East Anglia One North (EA1N) and East Anglia Two (EA2) Offshore Wind Farms

Planning Inspectorate Reference: EA1N – EN010077 & EA2 – EN010078

Deadline 9 – 15 April 2021

East Suffolk Council's Review of Actions Identified in the Local Impact Report

**Figure: 29.37f**  
**Viewpoint 5: Public Right of Way, near Moor Farm**

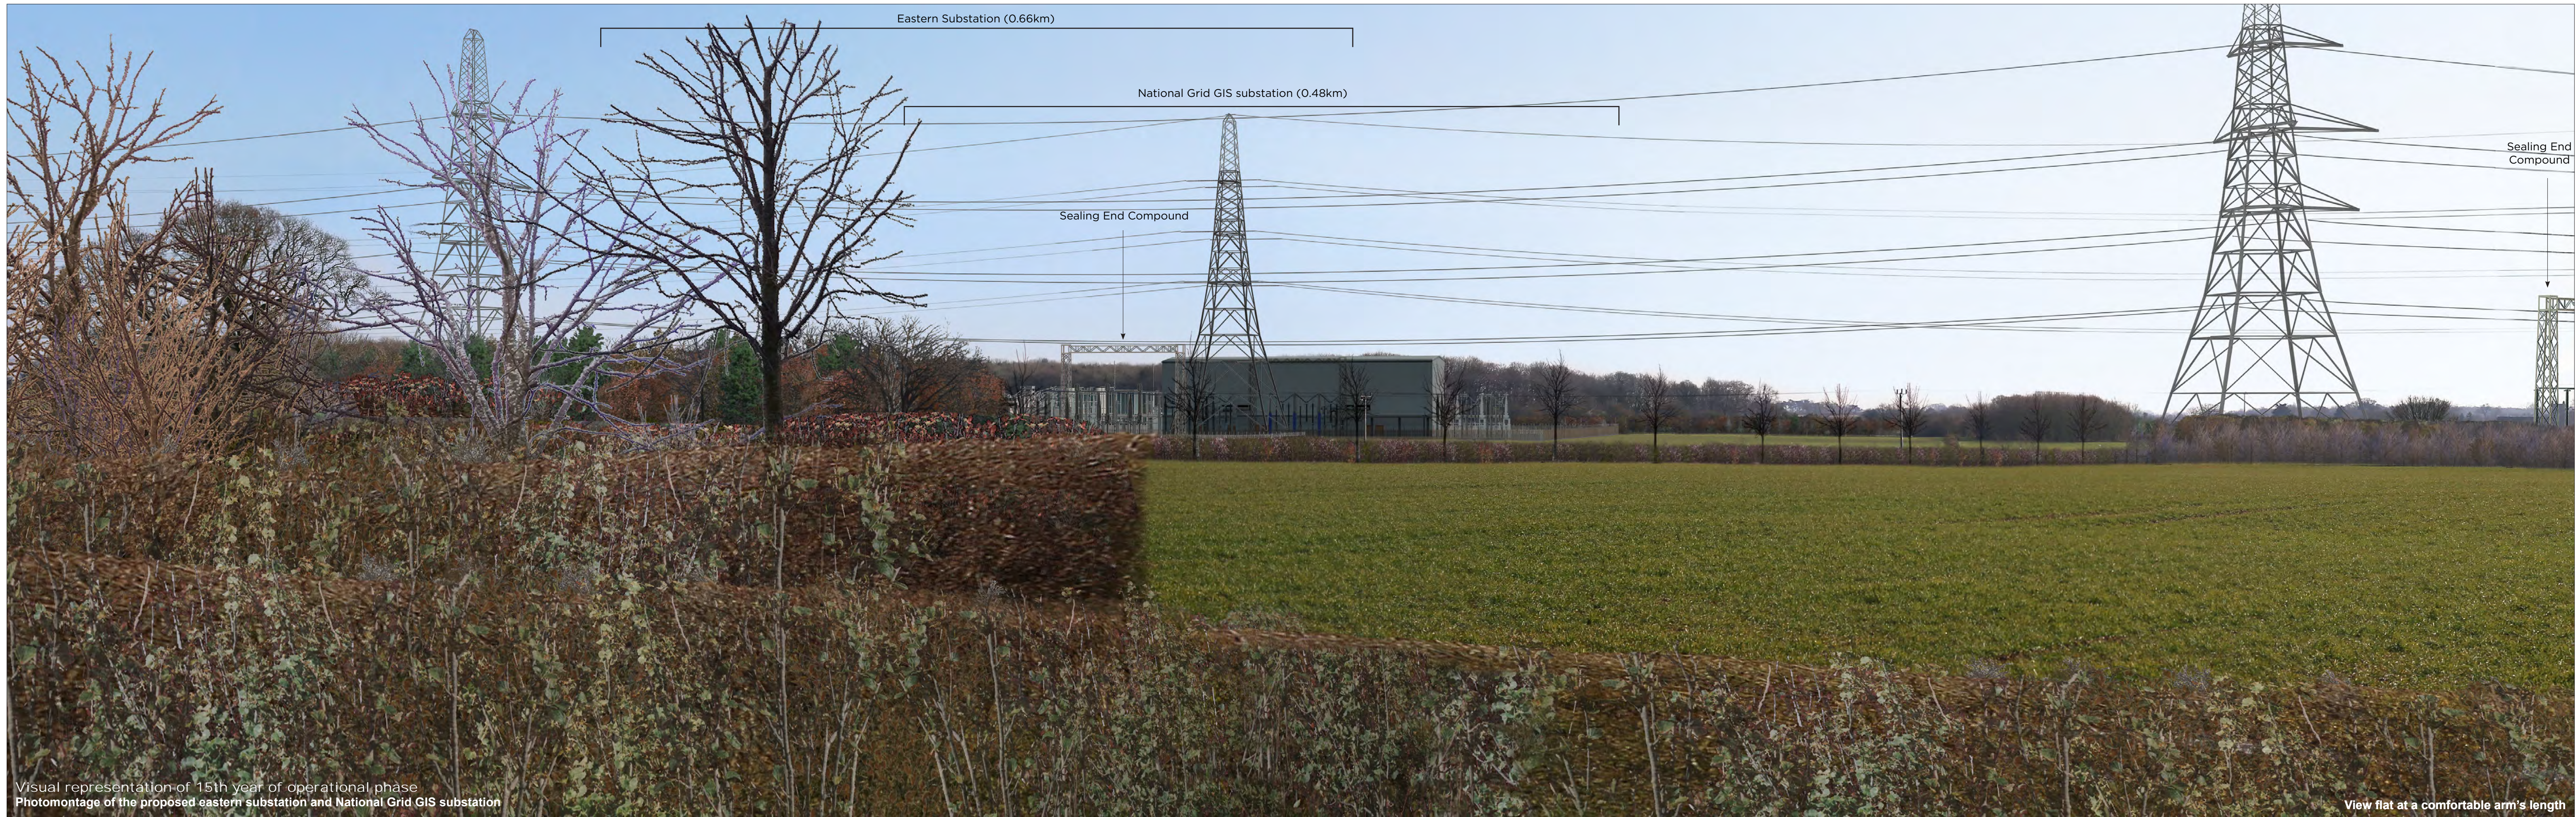
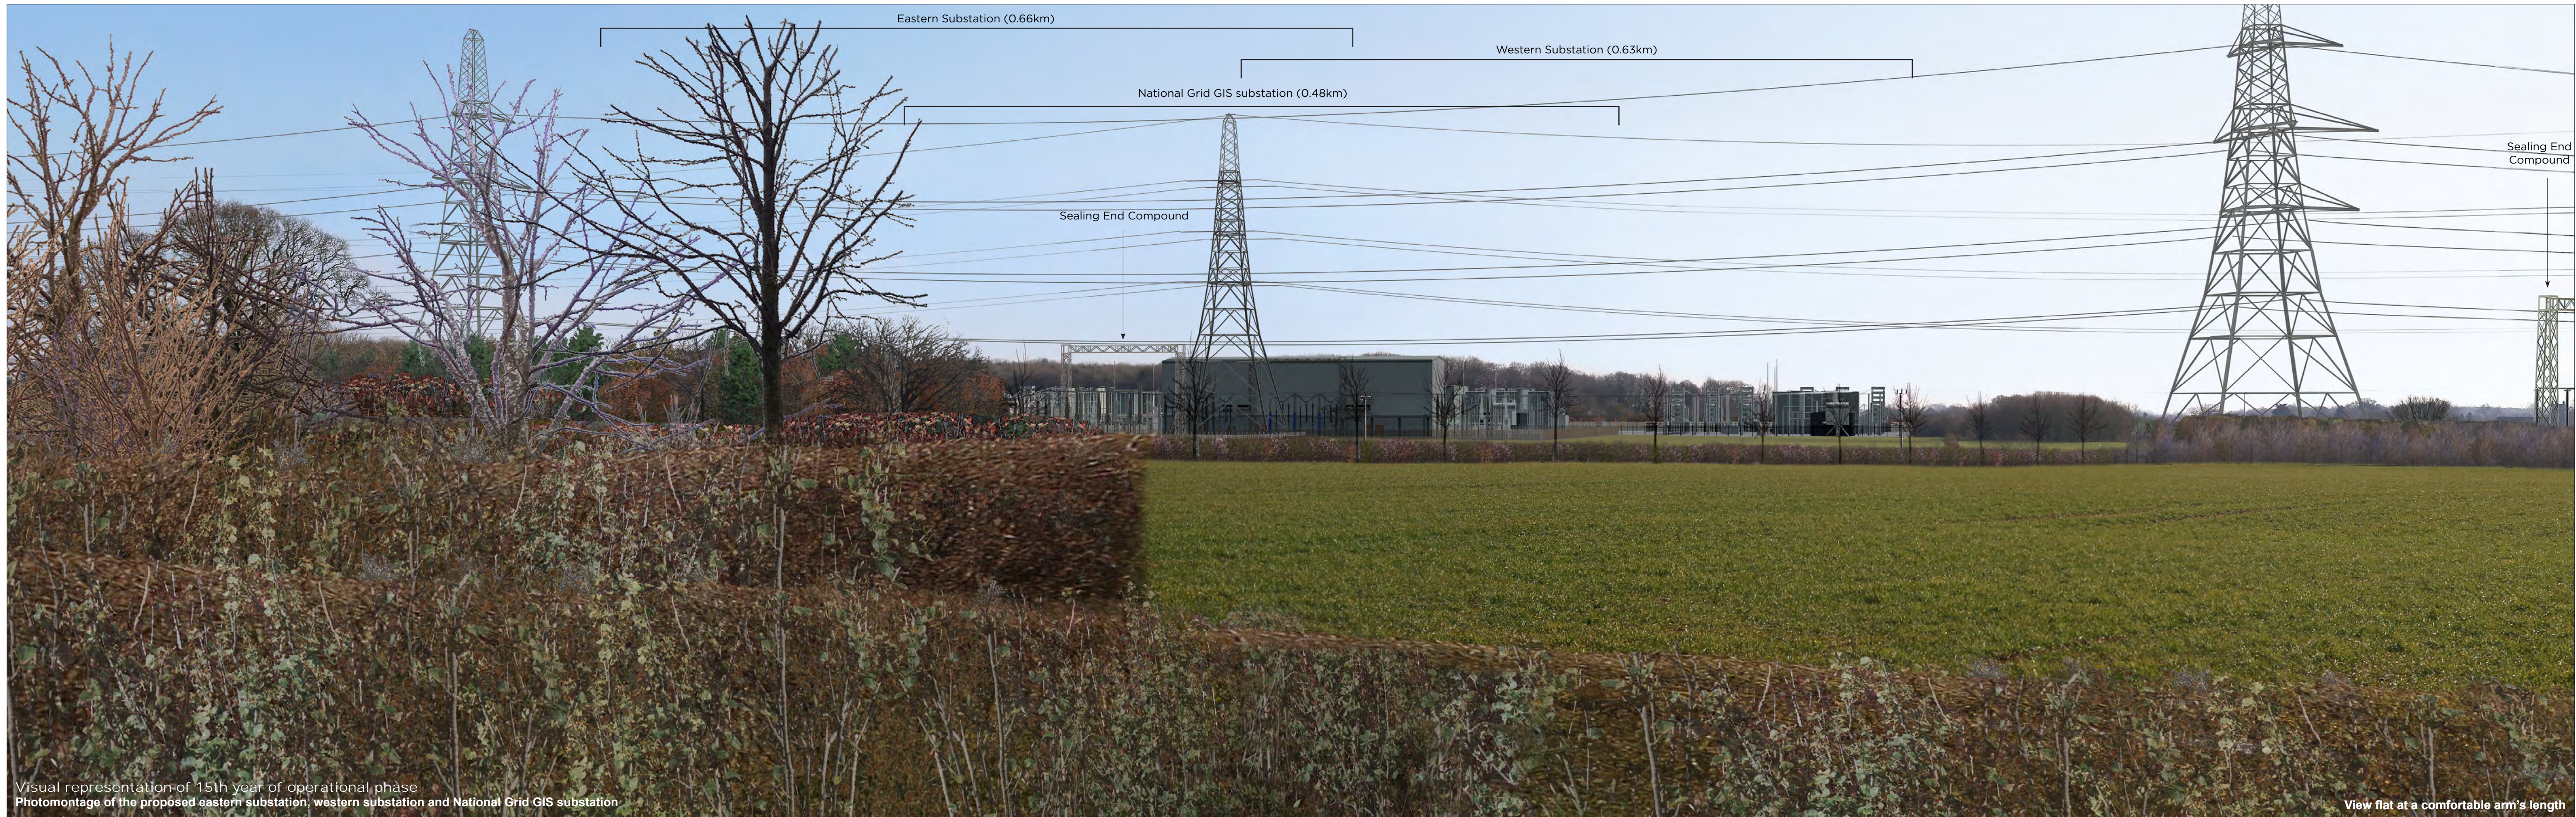
<p>visualisations is useful and welcomed but without full assessment of the GIS option for the National Grid substation, it is not possible for ESC to fully compare the impacts of the two technologies and assess the degree to which one technology is beneficial over the other. The lack of a full assessment of the GIS option also limits the Examining Authority’s ability to recommend to the Secretary of State that one technology should be favoured over another and prevents the ability for only the GIS option to be consented by the DCOs. The matter therefore remains outstanding.</p>
<p>Exploration of the opportunity to consolidate and share infrastructure in association with the BEIS OTNR.</p>		<p>The Applicants have stated that <i>‘it is not envisaged that the review will lead to opportunities or outcomes which would be relevant to the delivery of the projects’</i>, the reasons for this position have been set out in their written summary of case for Issue Specific Hearing 2 (ISH2, REP3-085). Ofgem has also supported this view with their oral submission at ISH2 and further written submission provided at Deadline 4 (REP4-096).</p> <p>To allow the potential for the design of the projects to adapt to the changing policy and technological environments, ESC supported SCC’s suggested wording for an additional design principle which could be incorporated into the Design Principles Statement (REP5-082)</p> <p><i>The detailed design of the project and the procurement processes that support it, will both engage with, respond to, and in so far as practicable, adopt and adapt to, any new opportunities arising from emerging new technologies and changes to legislation and regulations, in order to minimise the harms to the receiving environment and maximise the benefits of the project through good design. Engagement with the opportunities that may be offered from emerging technological, regulatory, and legislative change is a fundamental principle, that will be applied at all times, during the design procurement and development process.</i></p> <p>Following further discussions with the Applicants, it has been confirmed that engagement in relation to the design of the substations and infrastructure has already started to occur and will continue. ESC has been advised by the Applicants that it is not anticipated that there would be a significant delay between the consent of the projects and their design, this is</p>
